Consultation Response from KC, Conservation & Design
2024/90115 21-23, 25 and 27 Round Ings Road, Outlane, Huddersfield, HD3 3FQ

Alterations and renovations to existing dwellings 21/23, 25 and 27; erection of single storey extensions to existing dwellings 25 and 27; partial dismantling and re-building of detached barn; conversion and extension of detached and attached barns to form one dwelling; widening/improvements to existing access road, formation of parking and turning areas, together with hard and soft landscaping (Listed Building)

Date Responded: 13.3.2024
Responding Officer: Sue Brooks
Responding Ref: HUD 25/1150

typical external window elevations - the barn
scale 1:20

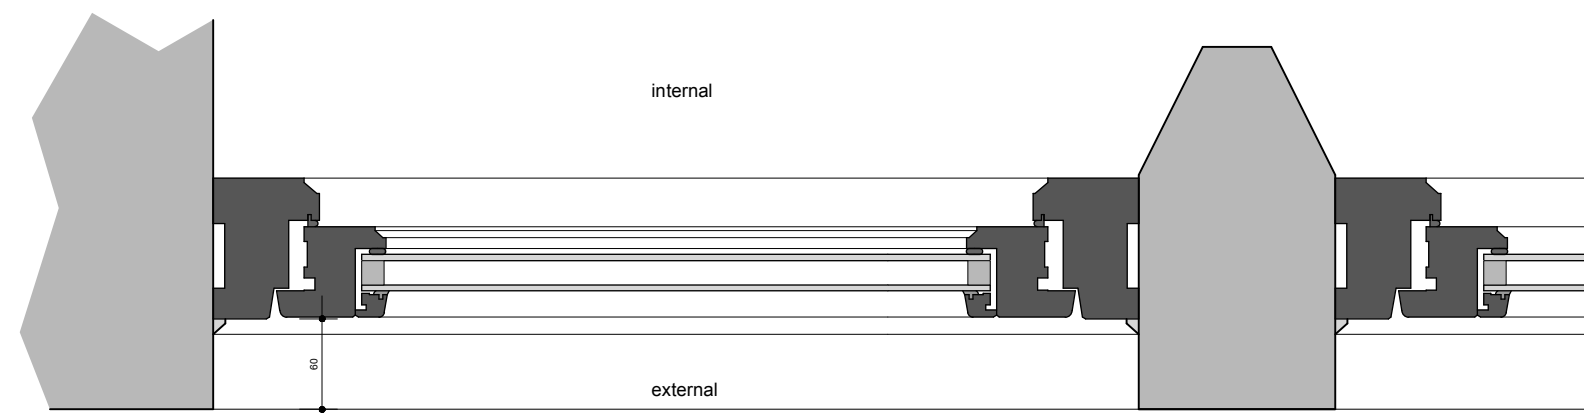
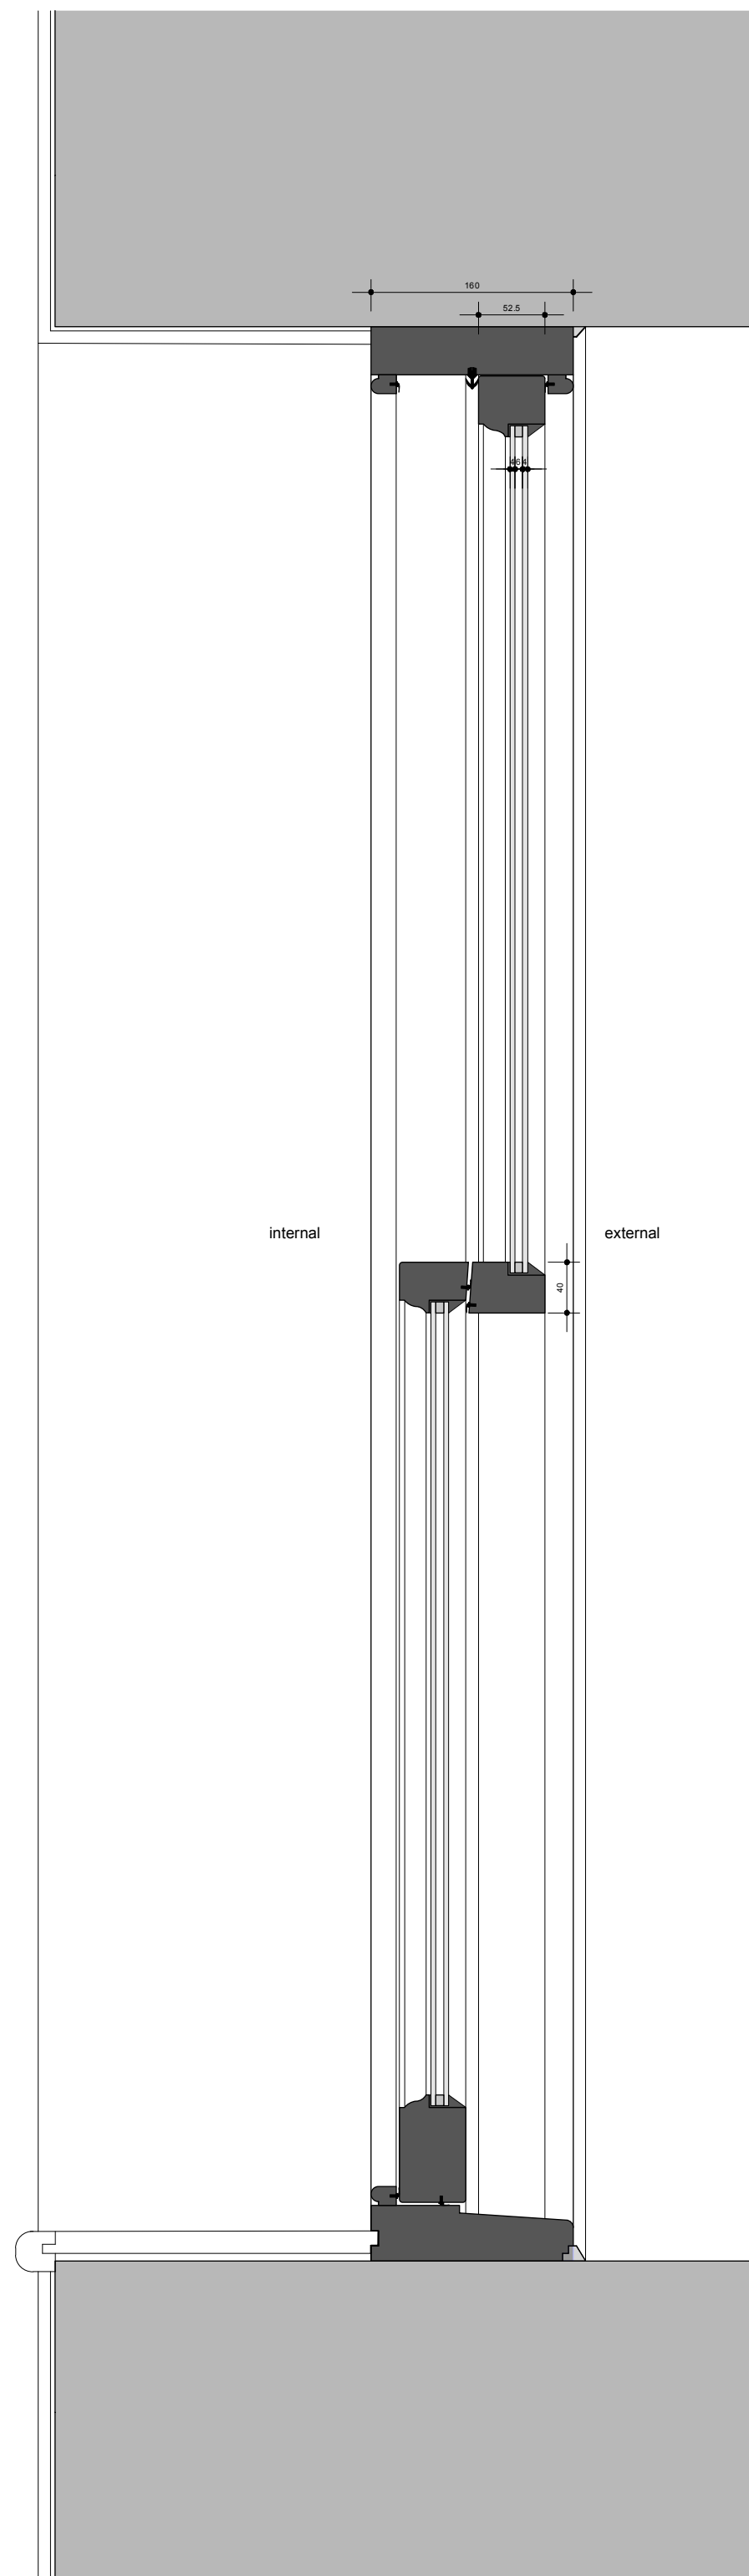
A large timber window is proposed within the existing cart entrance to replace the existing timber doors and replicate a pair of timber framed glazed doors. These are painted black and set back at least 140mm within the reveals to minimise the impact.

Note: As this is a fixed window, we would suggest that the frame sections are slimmer without the central section to reduce the massing. Details of how the first floor will interact with the barn doors are not clear and need to be submitted, along with redesigned cart entrance windows.

The window for this glazed entrance is a large timber framed window designed to replicate a pair of timber framed barn doors. The frames are painted black and set back at least 140mm within the reveals to minimise the impact.

Note: As with the main cart entrance, we would suggest that the frame sections of this fixed window are slimmer without the central section to reduce the massing.
